CITY OF PORTLAND BUILDING PERMIT

PERMIT ID: 2013-00333 **ISSUE DATE:** 04/11/2013 **CBL:** 131 H011001

has permission to **Create One Handicap Family unit - removing 2nd kitchen facilities & add new deck**

Proposed Use: Change of Use from two family to Single Handicap Family Unit (no more than 16 beds)	Proposed Project Description: Create One Handicap Family unit - removing 2nd kitchen facilities & add new deck
-------------------------------------------------------------------------------------------------------------	--------------------------------------------------------------------------------------------------------------------------

A1.3

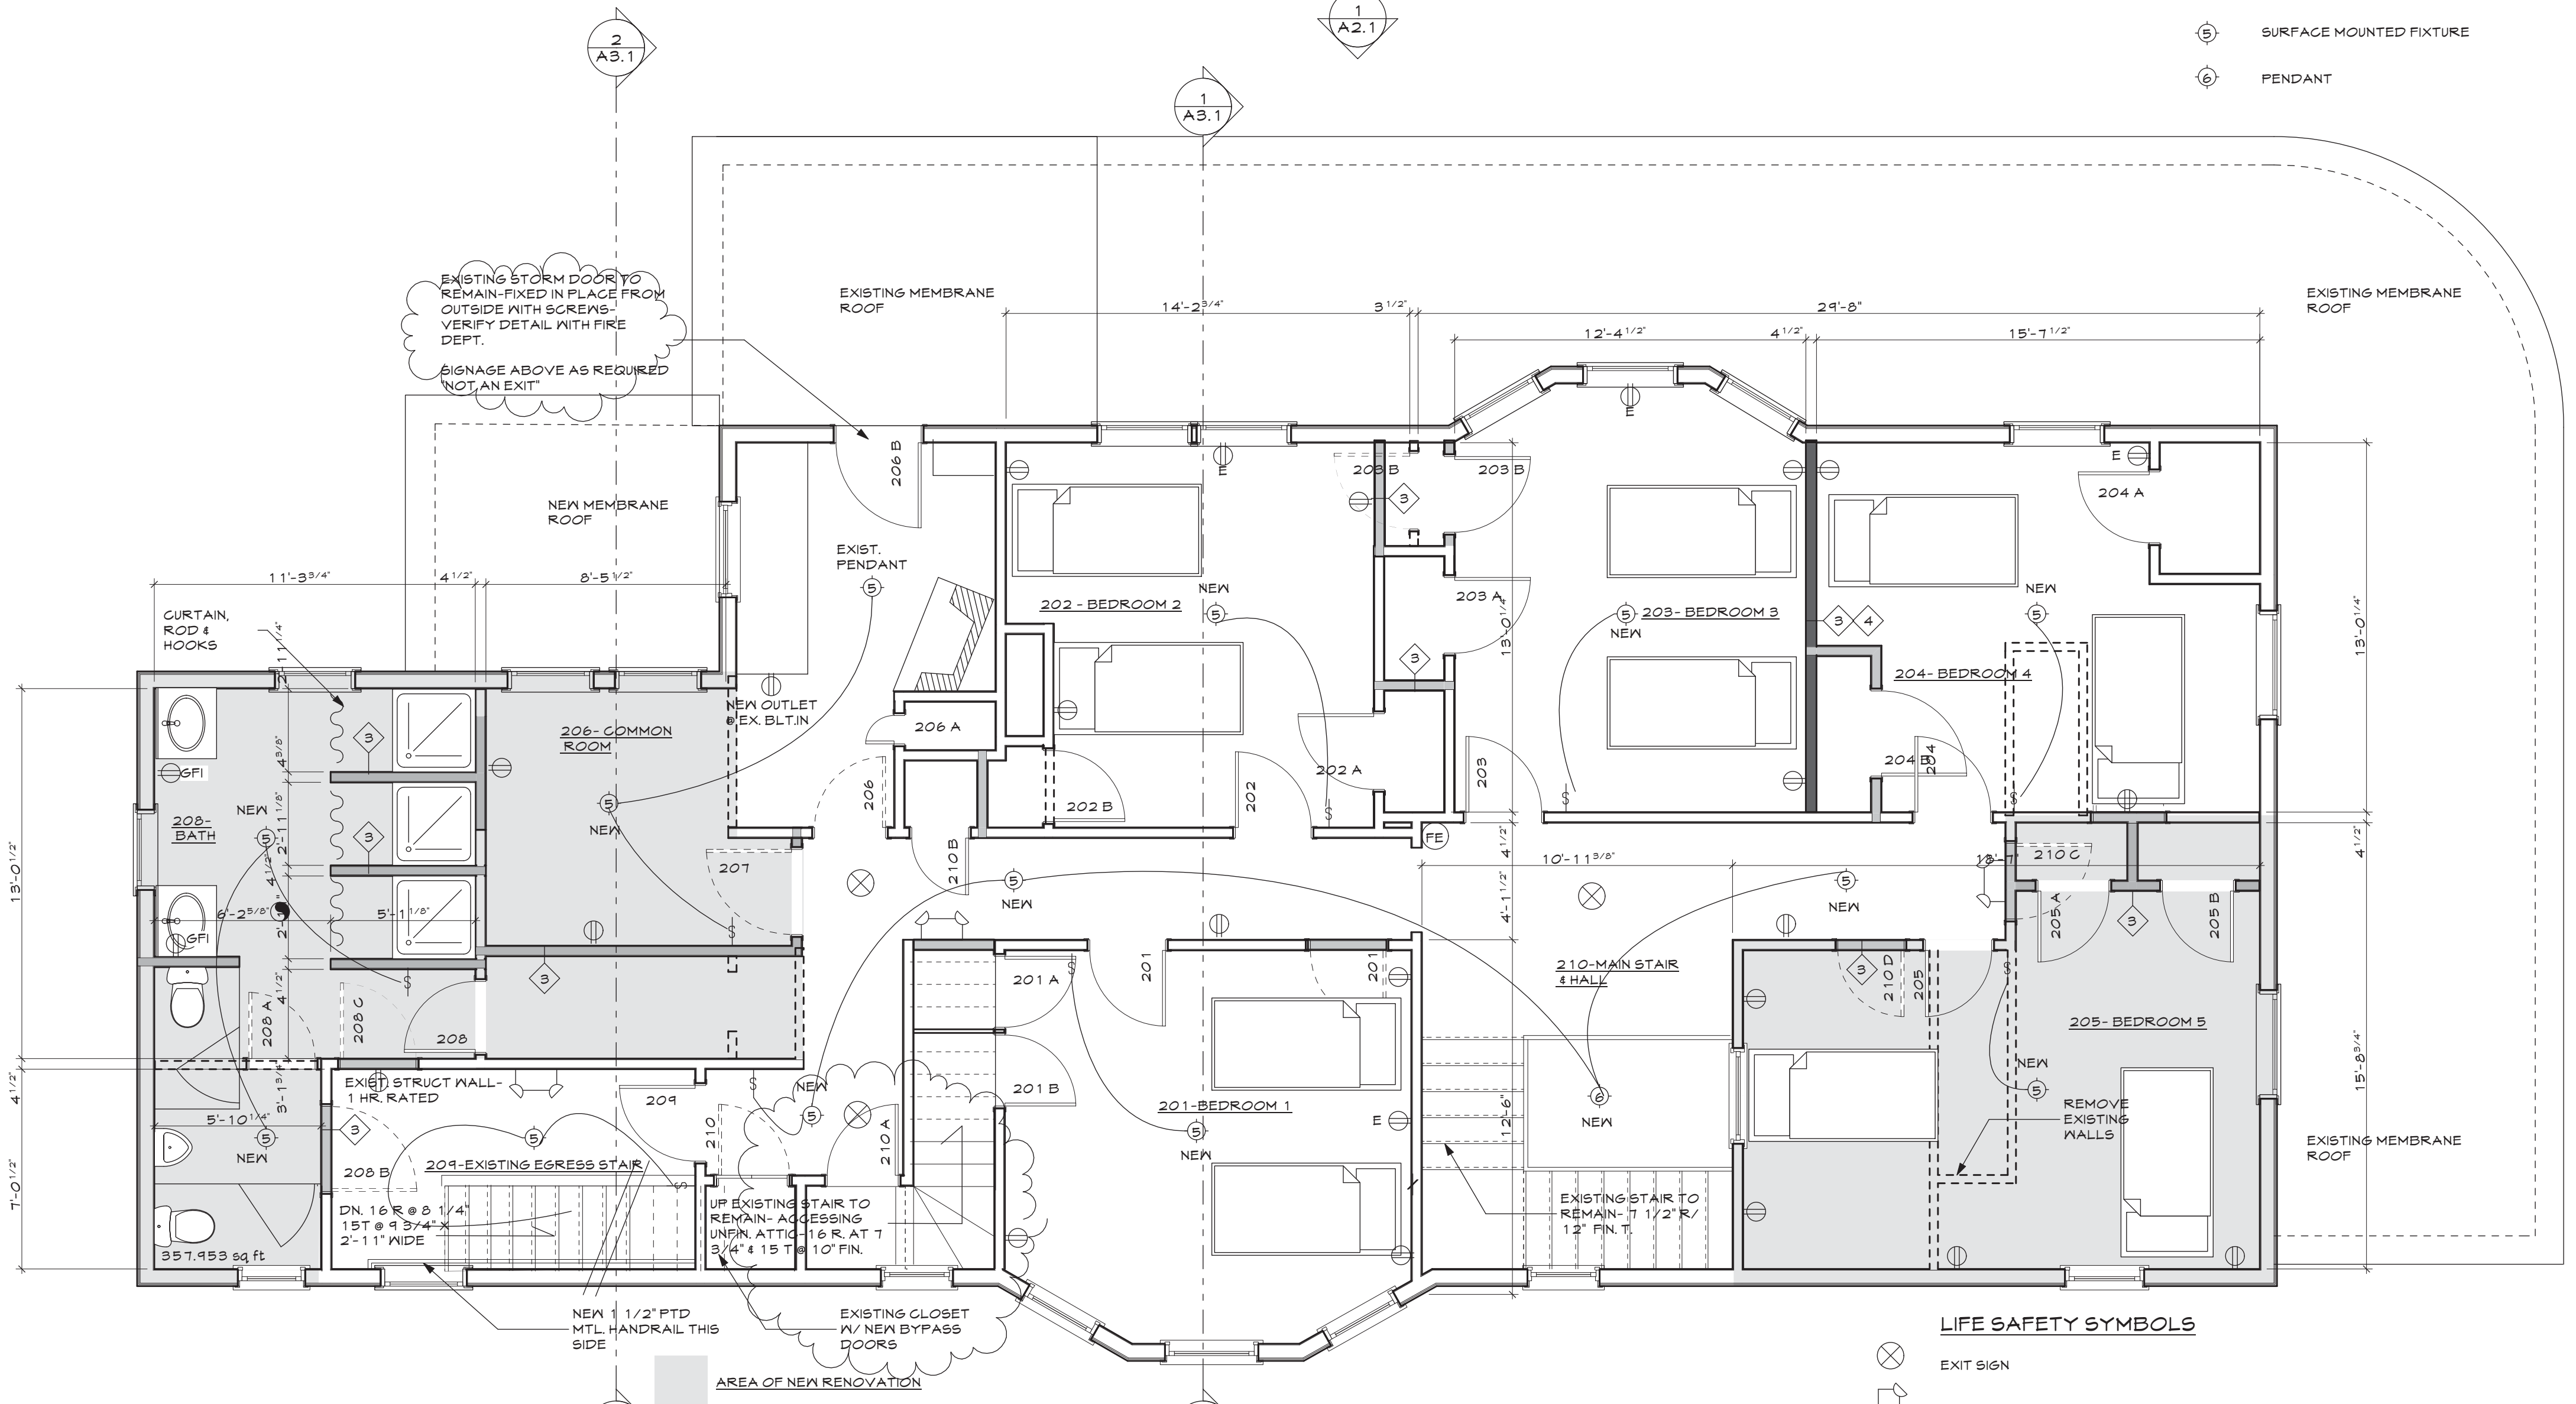
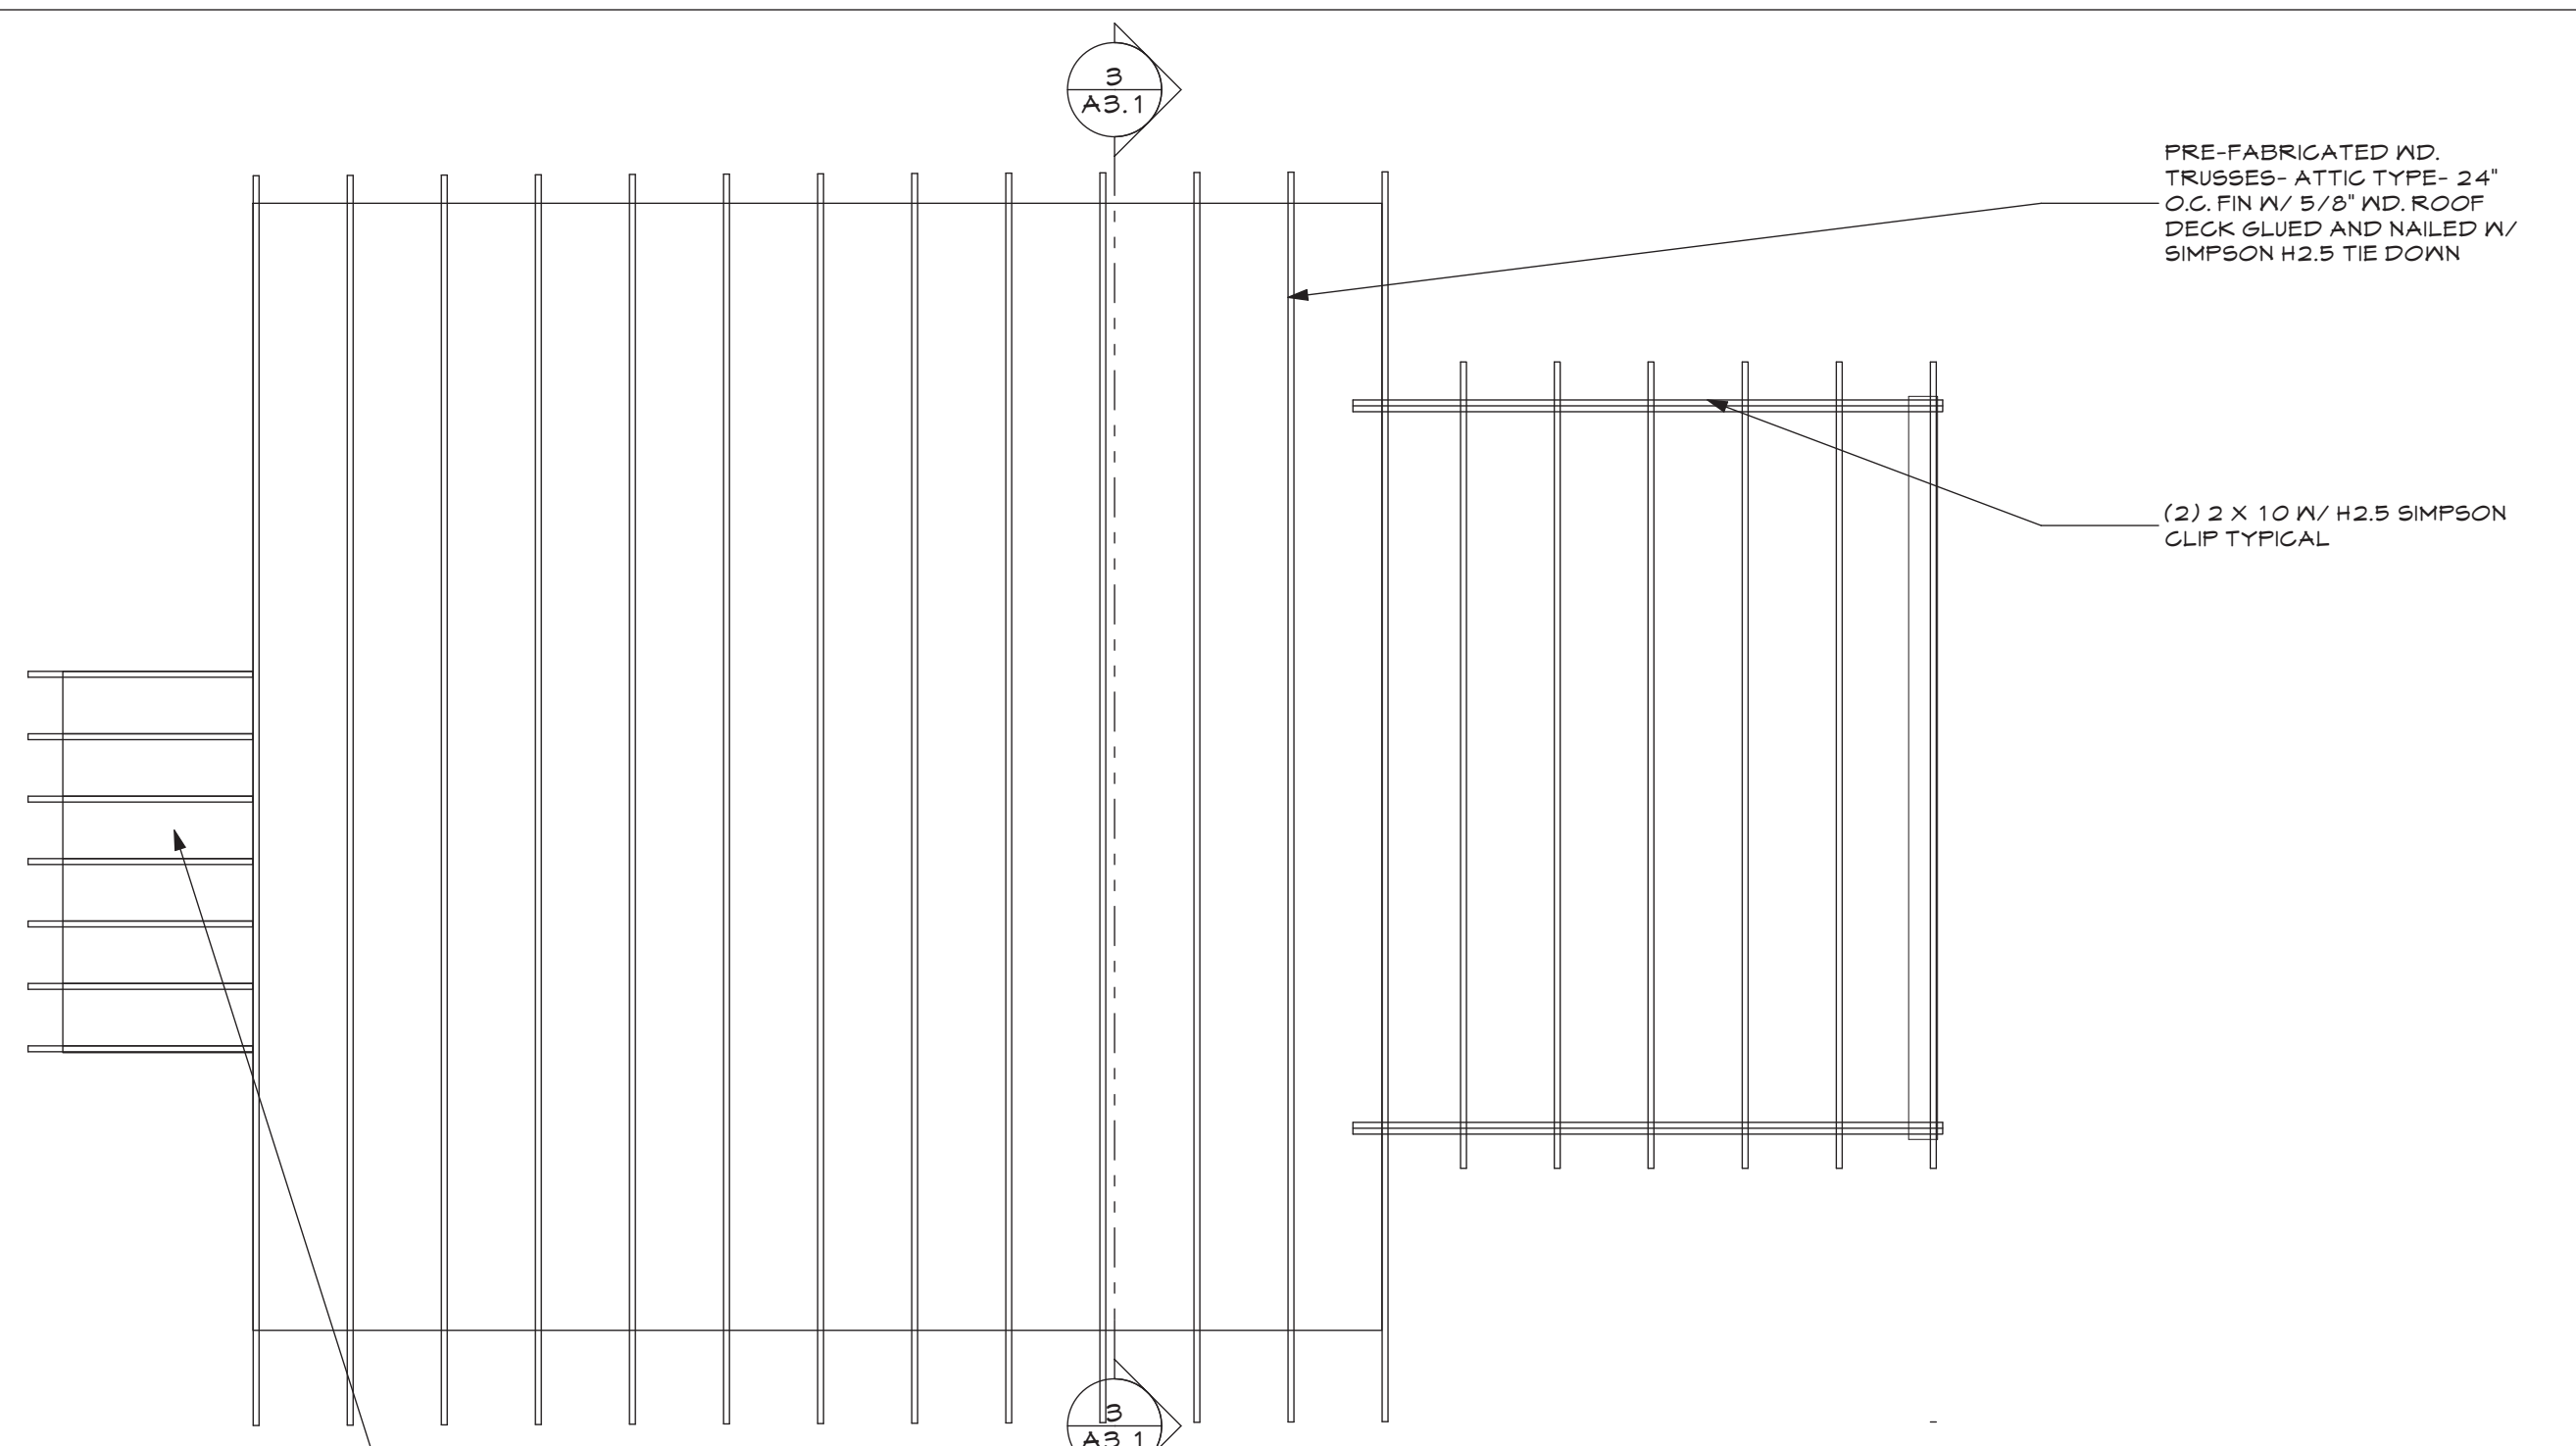
A1.3

Remove Door or provide Life Safety Code complaint "Not and Exit" with fall protection.

A1.1

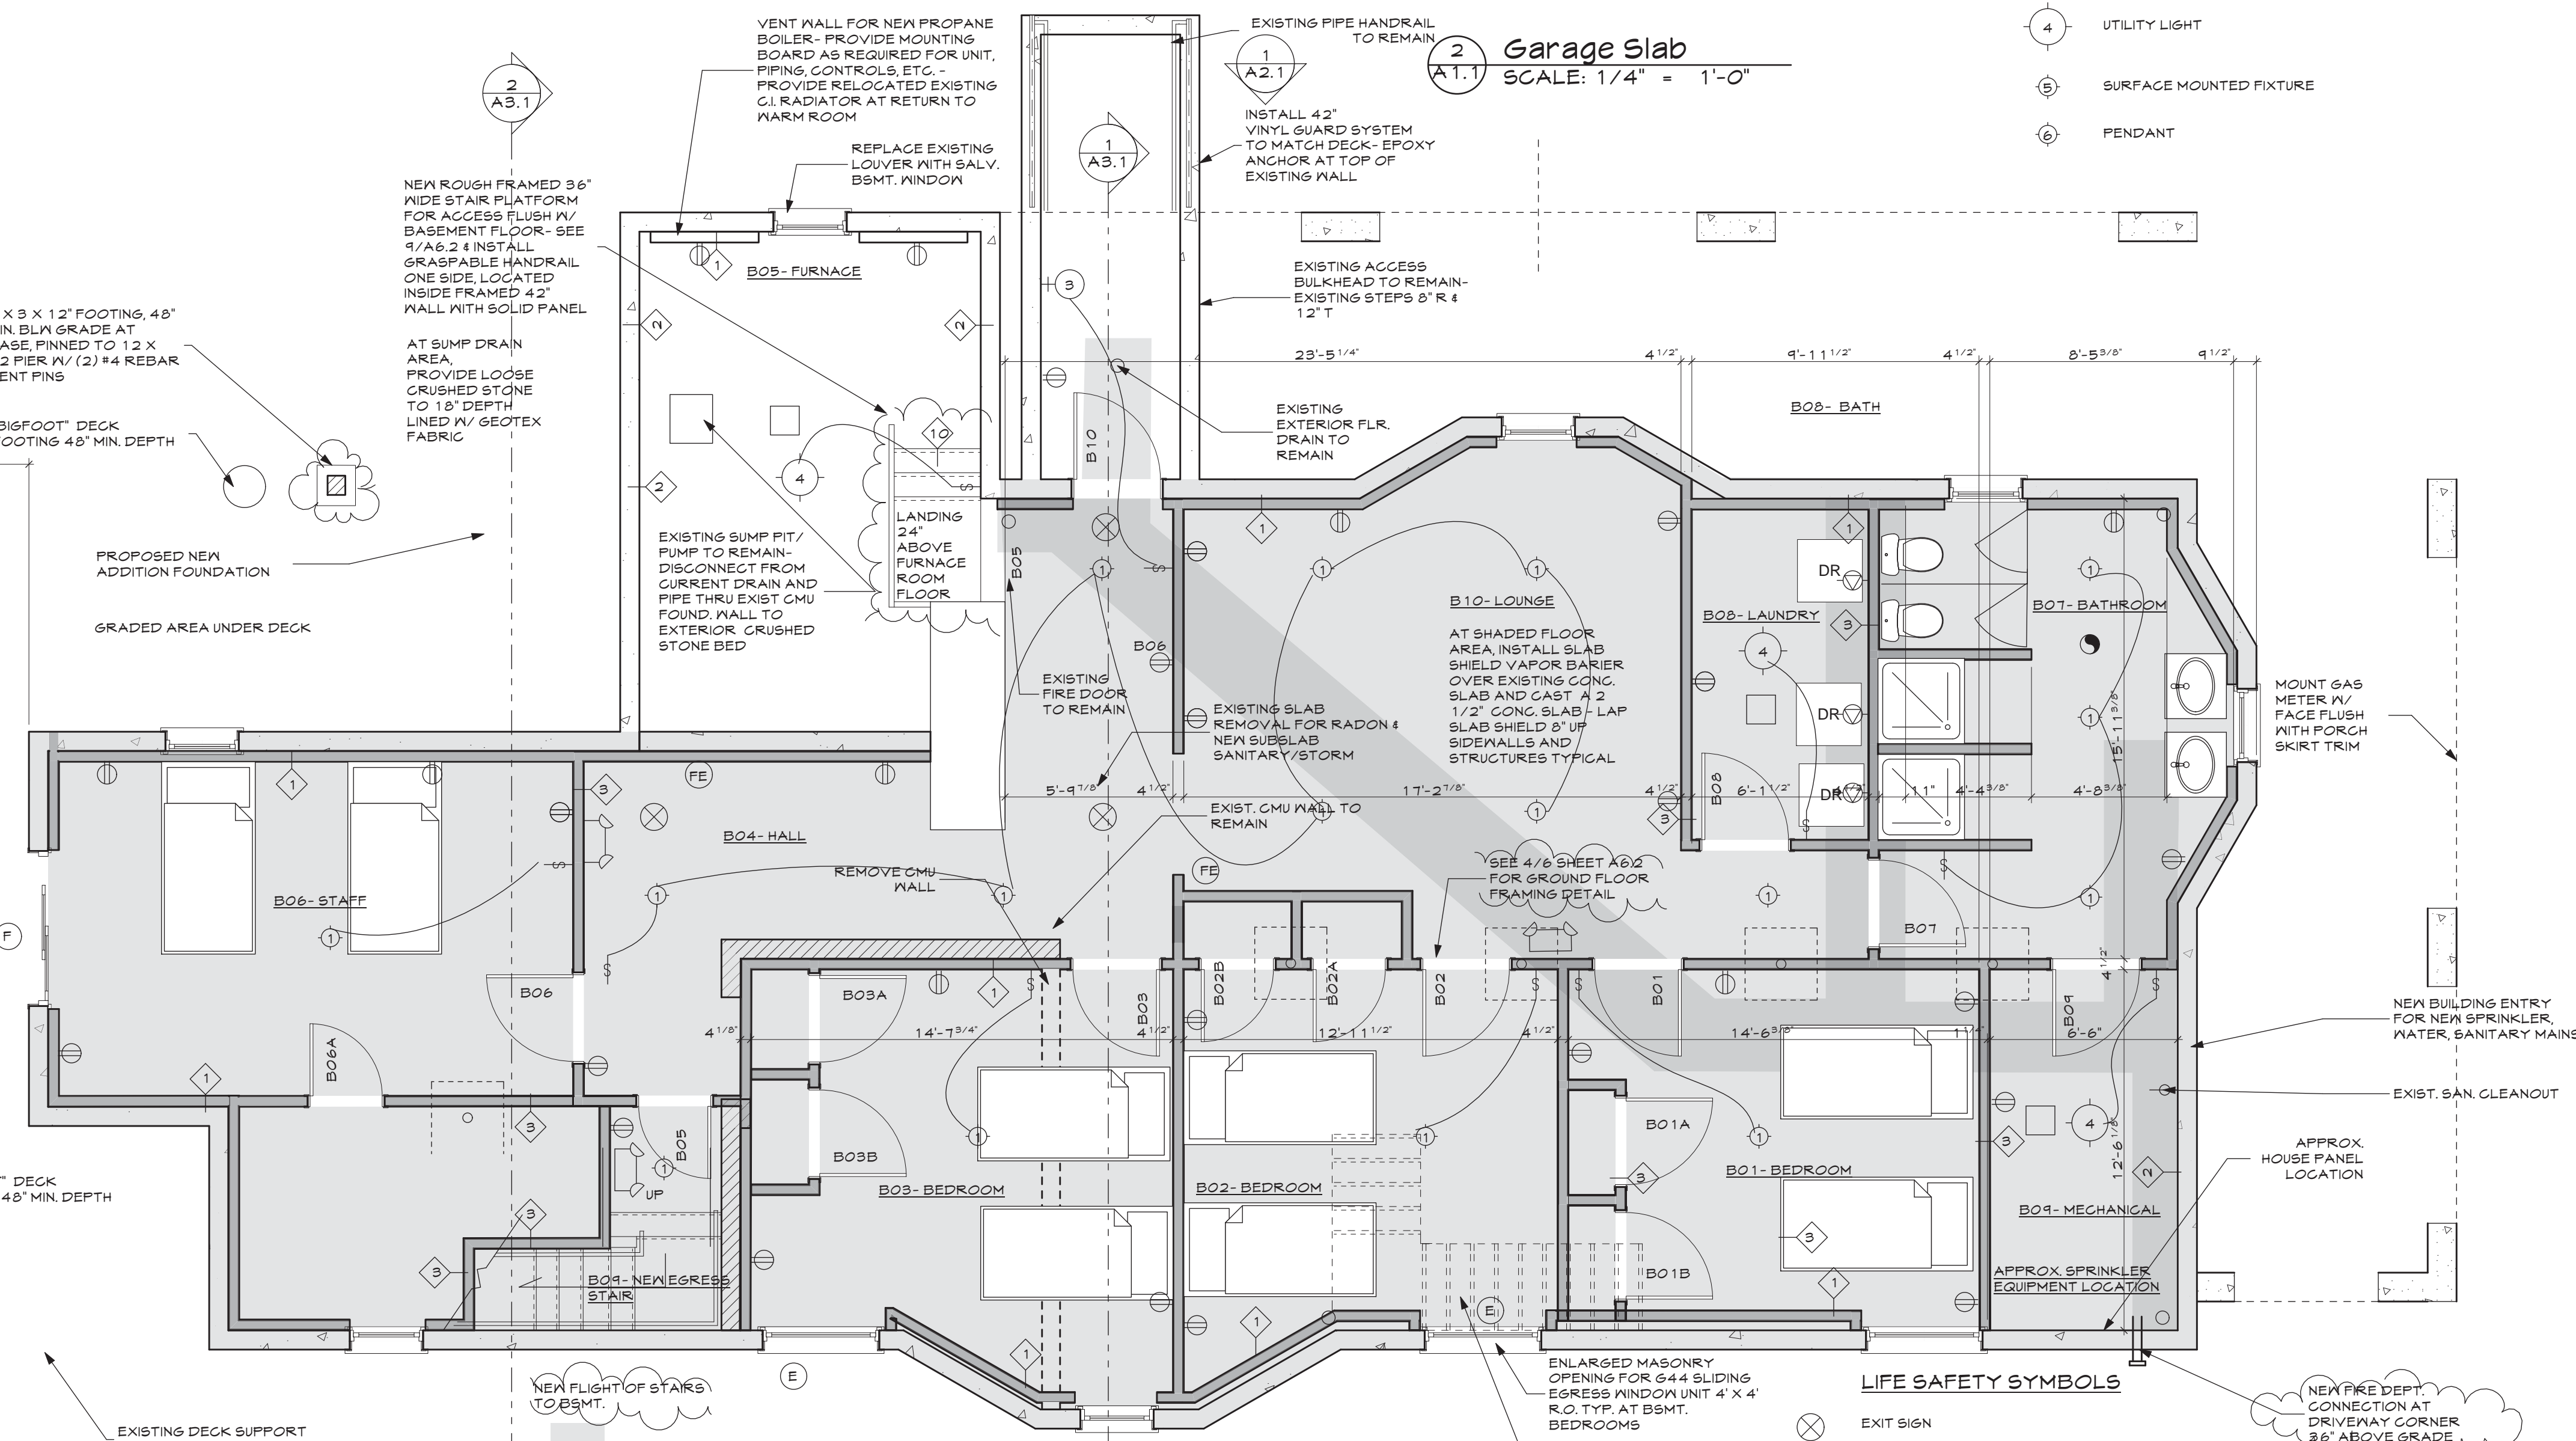
A1.1

Clarify Crawlspace & access

Cross Section for existing girders/ floor system (including Lally columns and footings)

Cross Section for stairways

Foundation Plan for the addition
